Inspector's Report ABP 306762-20

Whether the widening of existing private access road, infilling of marl hole and restoration and reuse of an existing derelict house as a habitable dwelling is or is not development or is or is not exempted development

Ballina Upper, Blackwater, County Wexford.

Planning Authority	Wexford County Council
Planning Authority Reg. Ref.	EXD00793
Applicant for Declaration	Frances Hopkinson
Planning Authority Decision	Is Exempted Development

INFORMATION			
TITLE	BOUNDARY DISPUTE		
AT	BALLINA UPR BLACKWATER CO. WEXFORD		
FOR	ARTHUR & FRANCES HOPKINSON		
DWG.	SITE PLAN & SECTION WITH PHOTO		
SCALE	1:50	JOB NO	19-012
DATE	12/2019	DRN	PHILIP BYRNE
		DRAWING NO	001
		REV	-

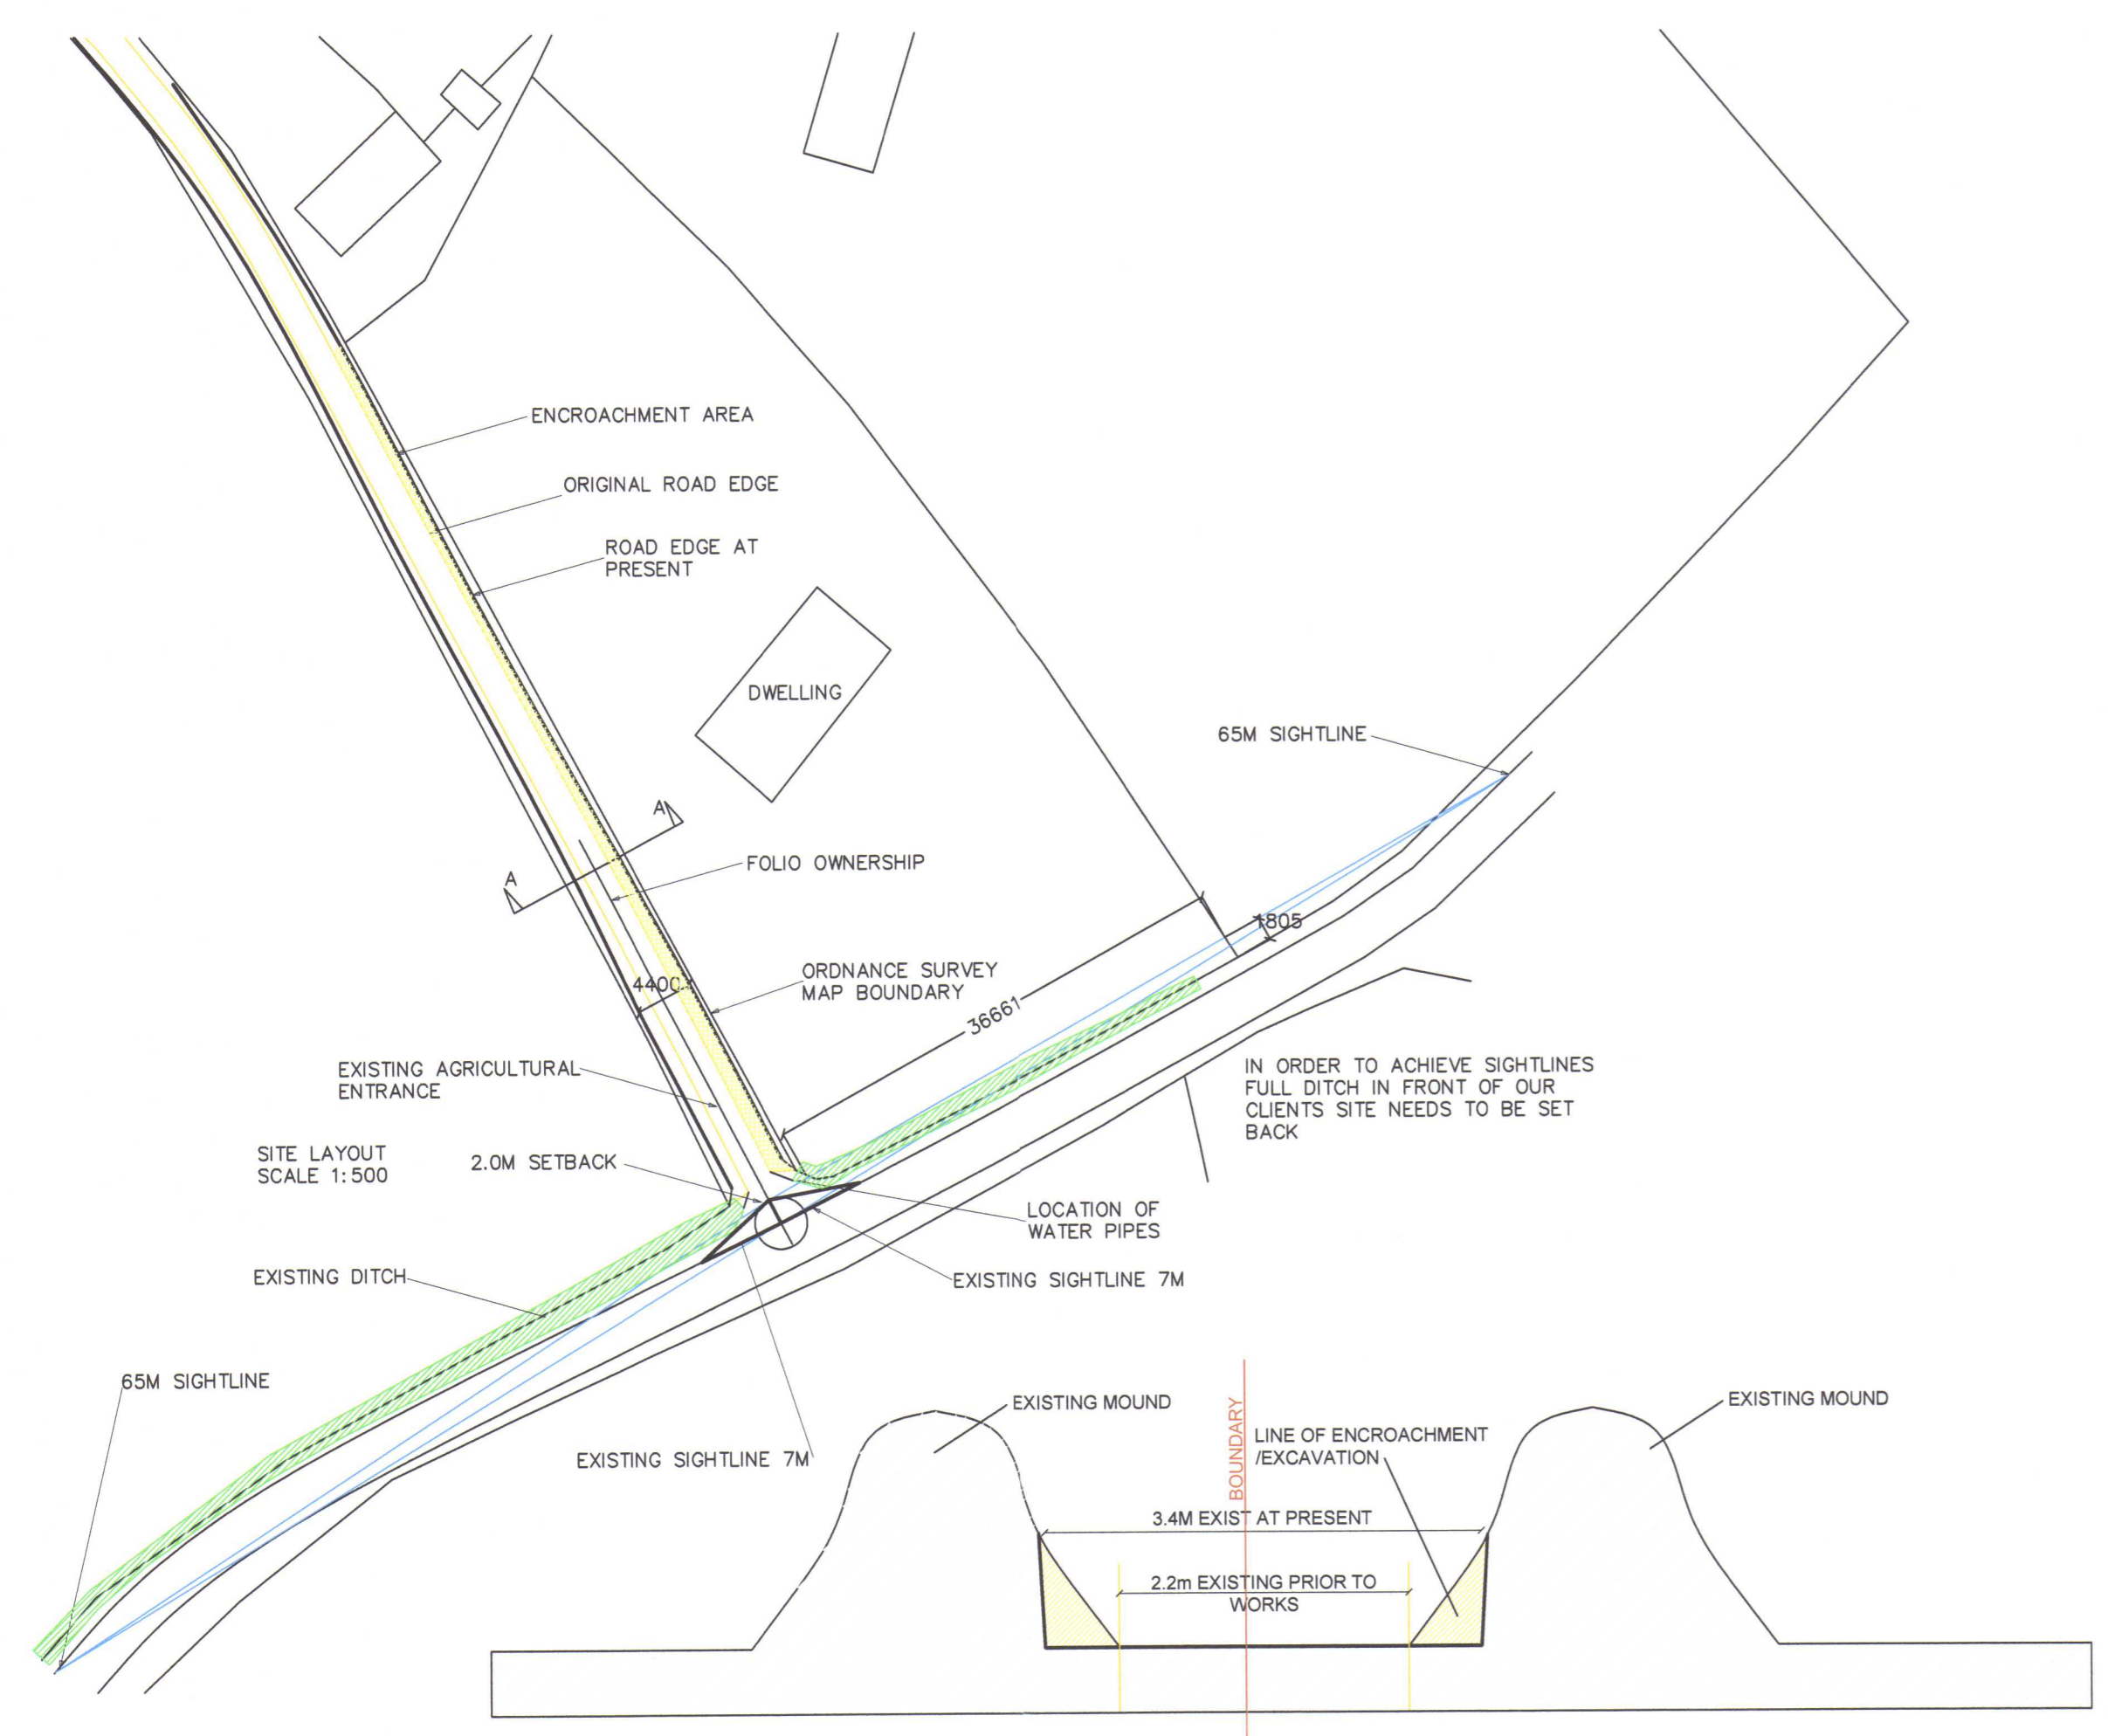
8.3.3. On the site inspection, I measured the width of the private roadway in several places. The roadway is not uniform throughout its length with some sections being c. 3m and some sections increasing to over 4.2m in width. I note from the drawings submitted with the referral that the original width of the private road was stated to be 2.2m. As the private access is now over 3m in width, the access does not conform with the limitations set down in Class 13 of the Regulations and is not exempted development.

8.4.3. Having inspected the site and the engineering drawings provided by the referrer, I consider that the existing access constitutes a traffic hazard and as such, the restriction of an exemption as set out in Article 9(1)(a)(iii) would not apply to this case.
